From: Emma Avis [REDACTED]
Sent: 09 July 2019 16:51
To: Anita Gardner <Anita.Gardner@arun.gov.uk>
Subject: RE: Scyld - Highways

The Local Highway Authority does not consider that the proposal would have an unacceptable impact on highway safety or result in 'severe' cumulative impacts on the operation of the highway network, therefore is not contrary to the National Planning Policy Framework (paragraph 109), and that there are no transport grounds to resist the proposal. The following conditions should be applied to any grant of planning consent.

drawing number
FIGURE 1.3

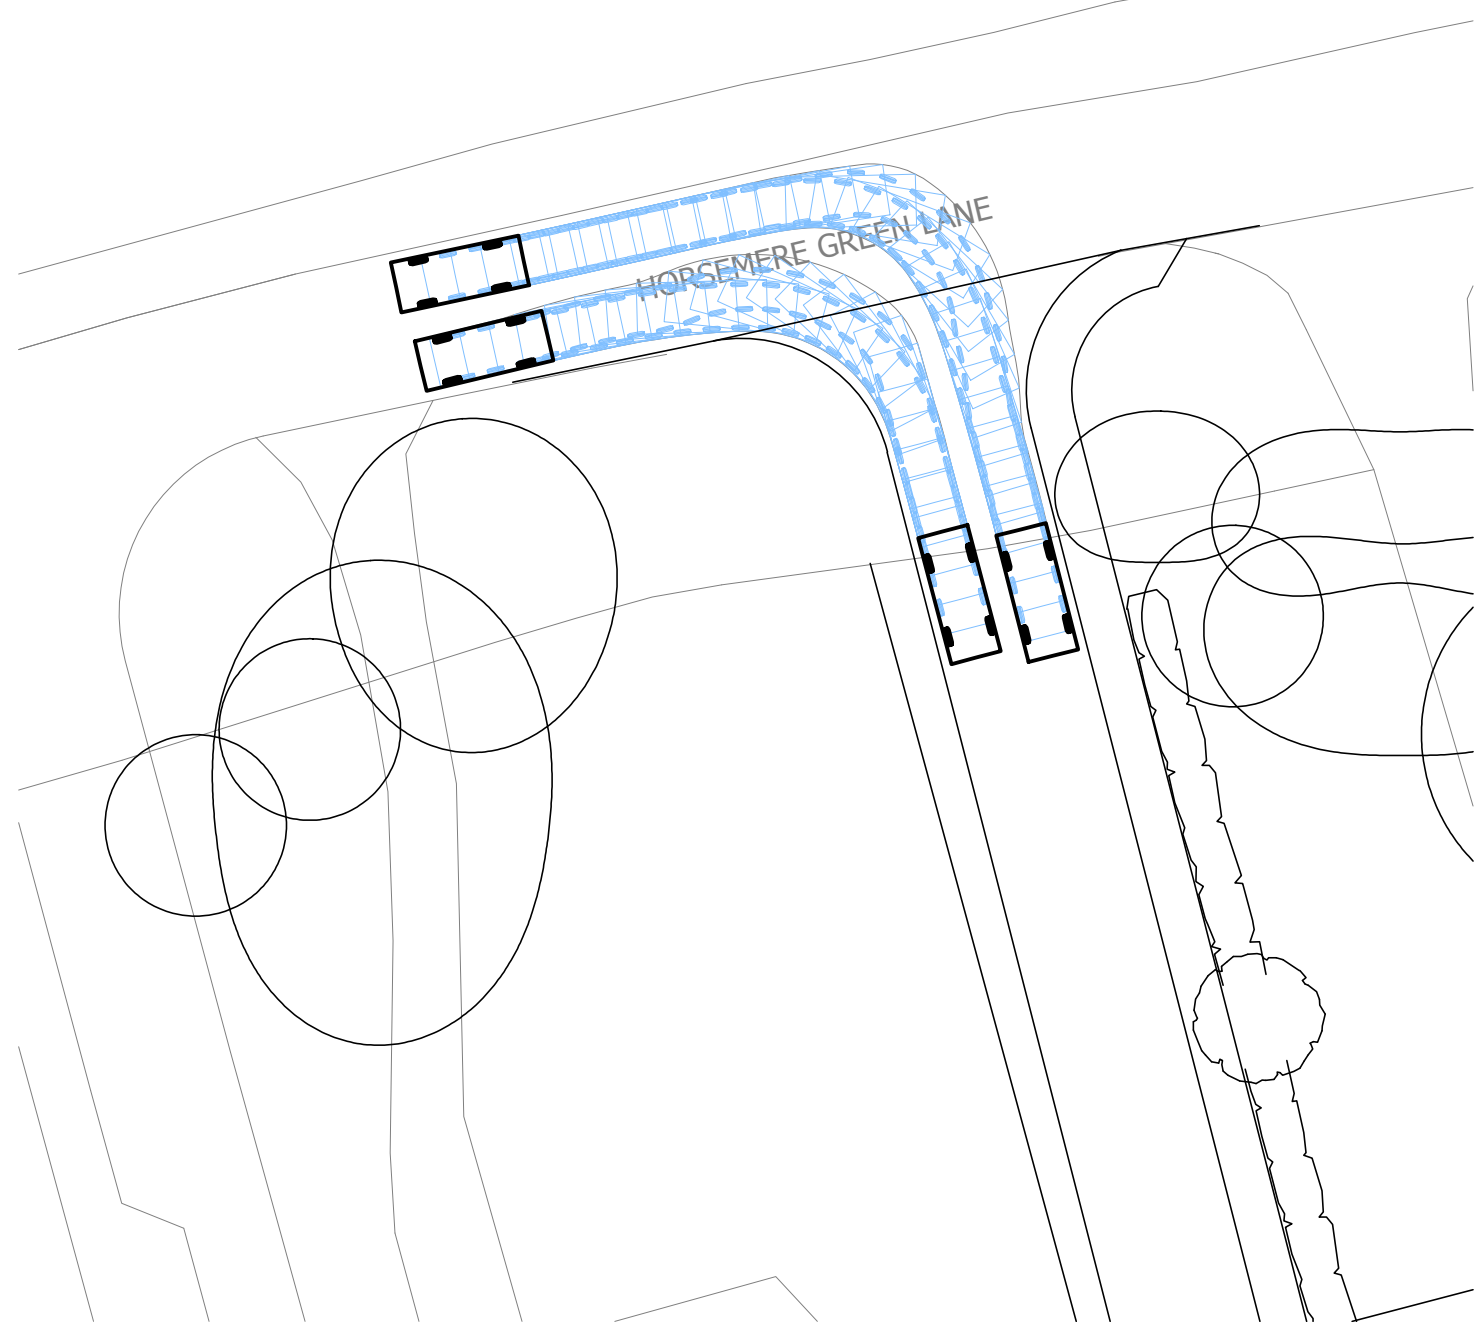
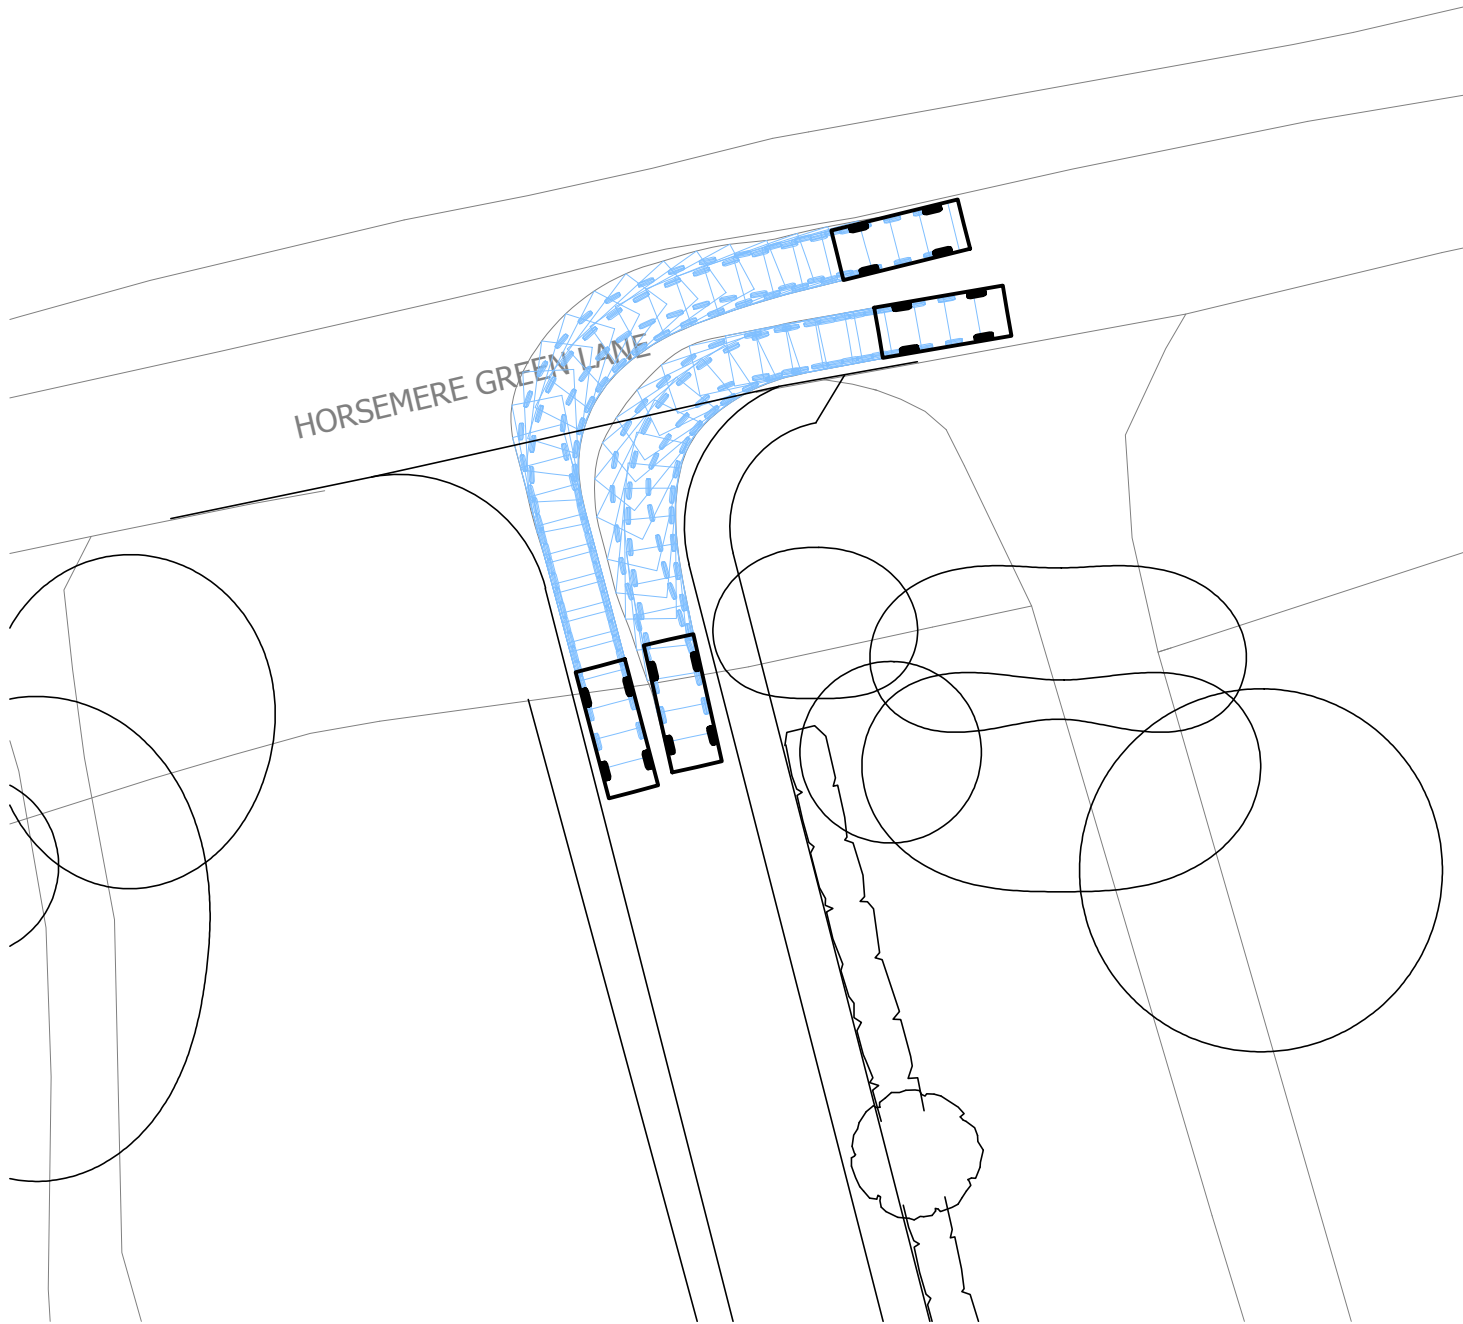
The maximum visibility splay was requested to demonstrate what could be achieved, given concerns raised about road speeds, in light of there being no speed survey data provided. It's clear that in excess of 43m (in line with Manual for Streets parameters) is achievable. The build out acts as a traffic calming feature and given its proximity to the proposed access, the speed of approaching vehicles are likely to be low.

No part of the development shall be first occupied until such time as the vehicular access serving the development has been constructed in accordance with the details shown on the drawing no: FIGURE 1.3 Rev P2.

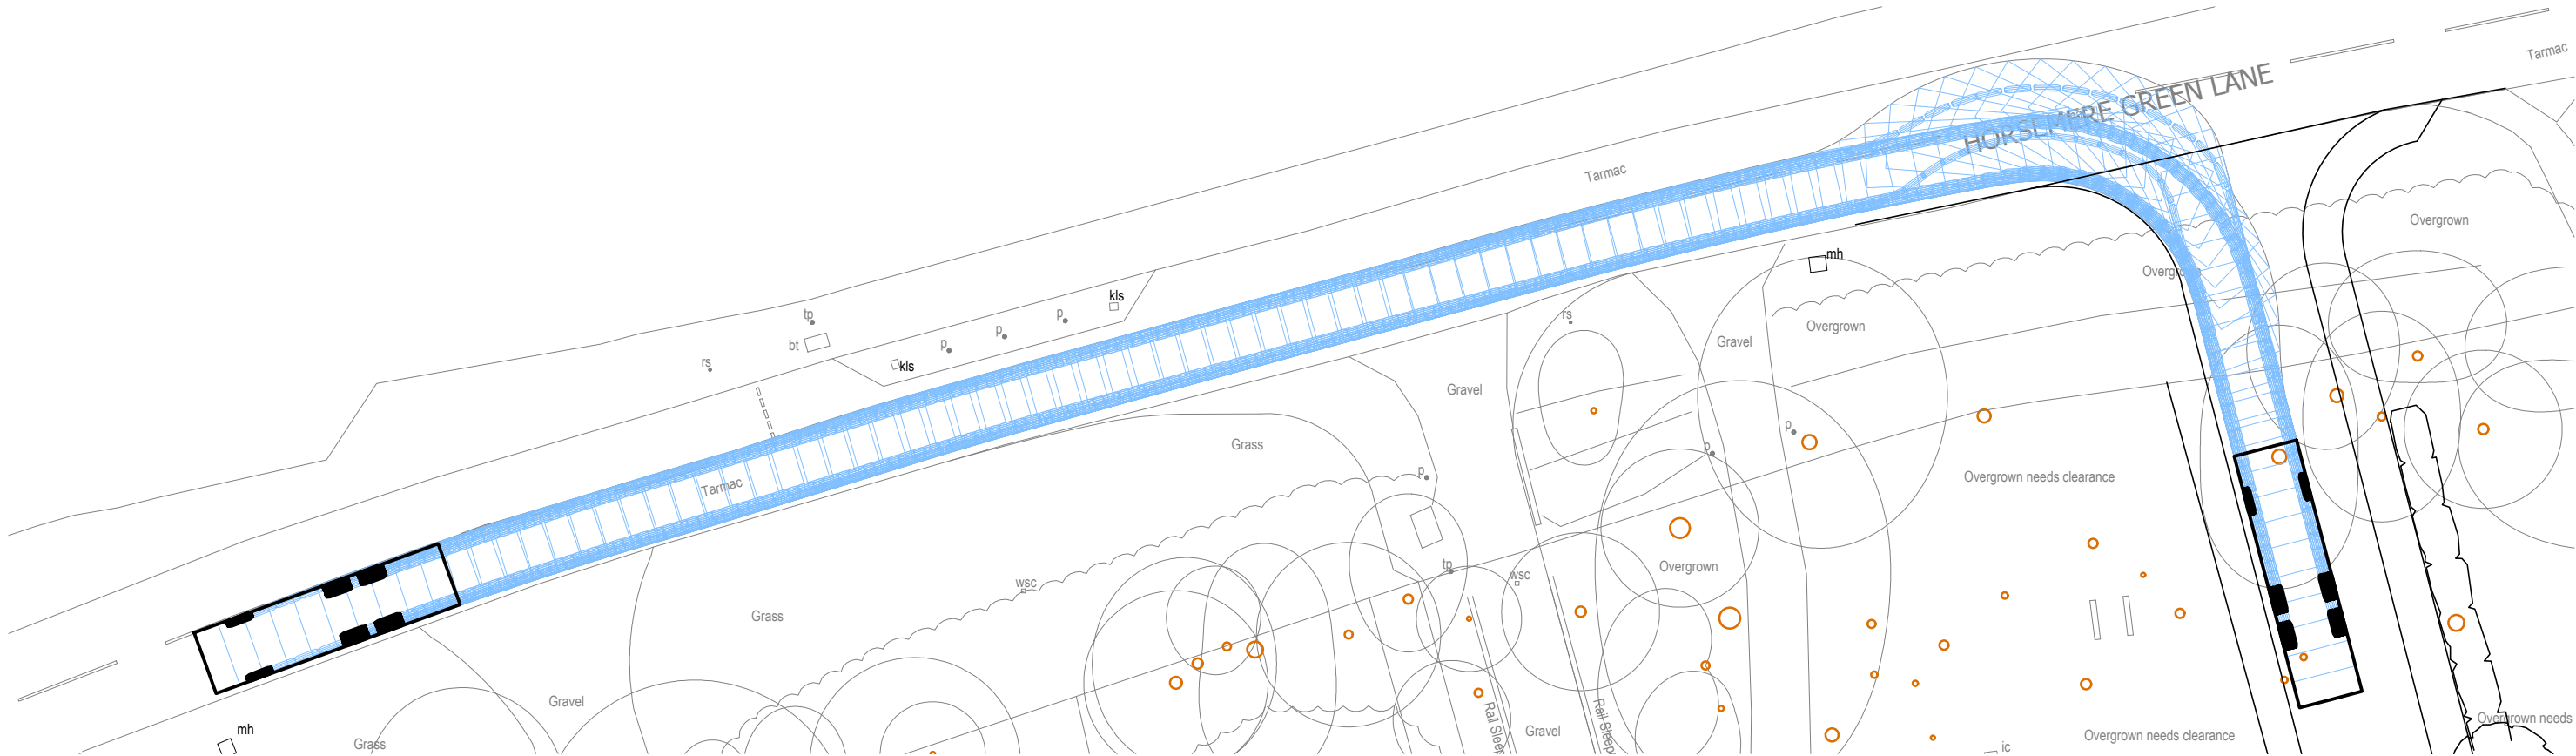
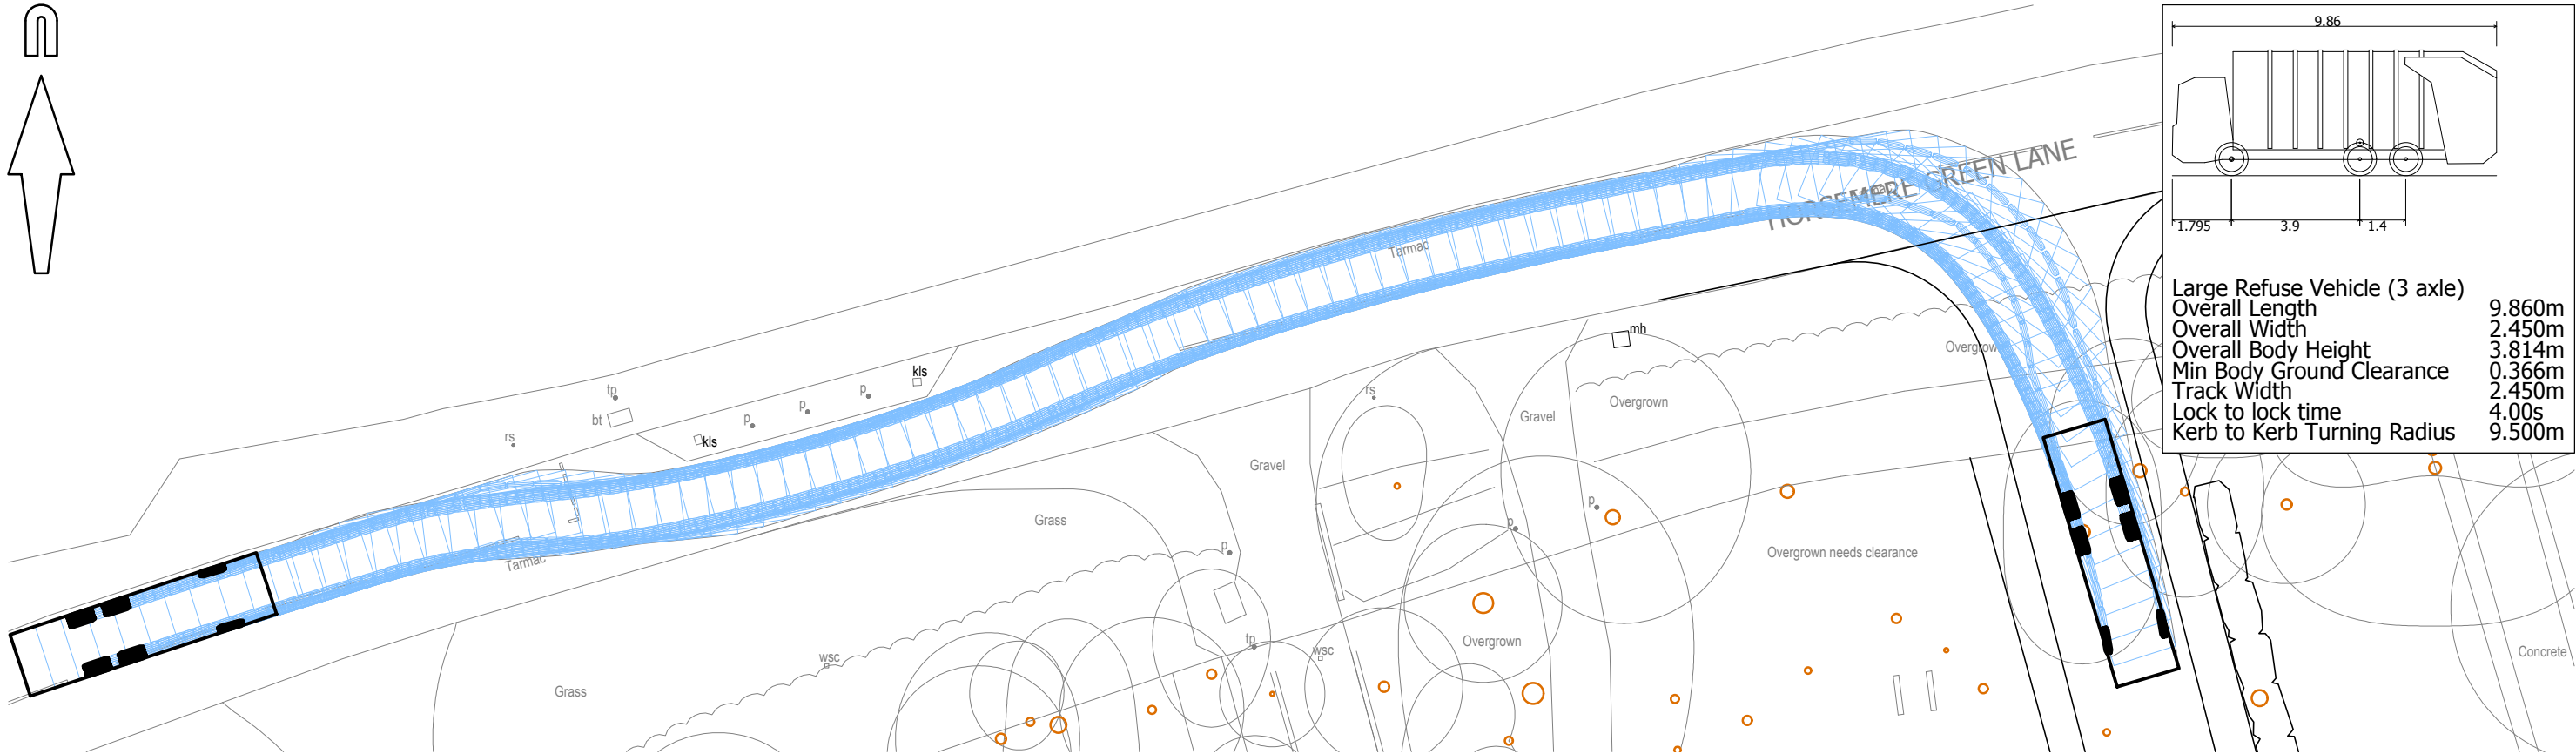
The LHA would raise no concerns to the tracking diagram showing the build out. Yes the refuse truck will cross the centreline, but this is not unusual for this type of road/area.

Tracking has also been provided to show that the 'build out' does not impact ingress or egress to the site.
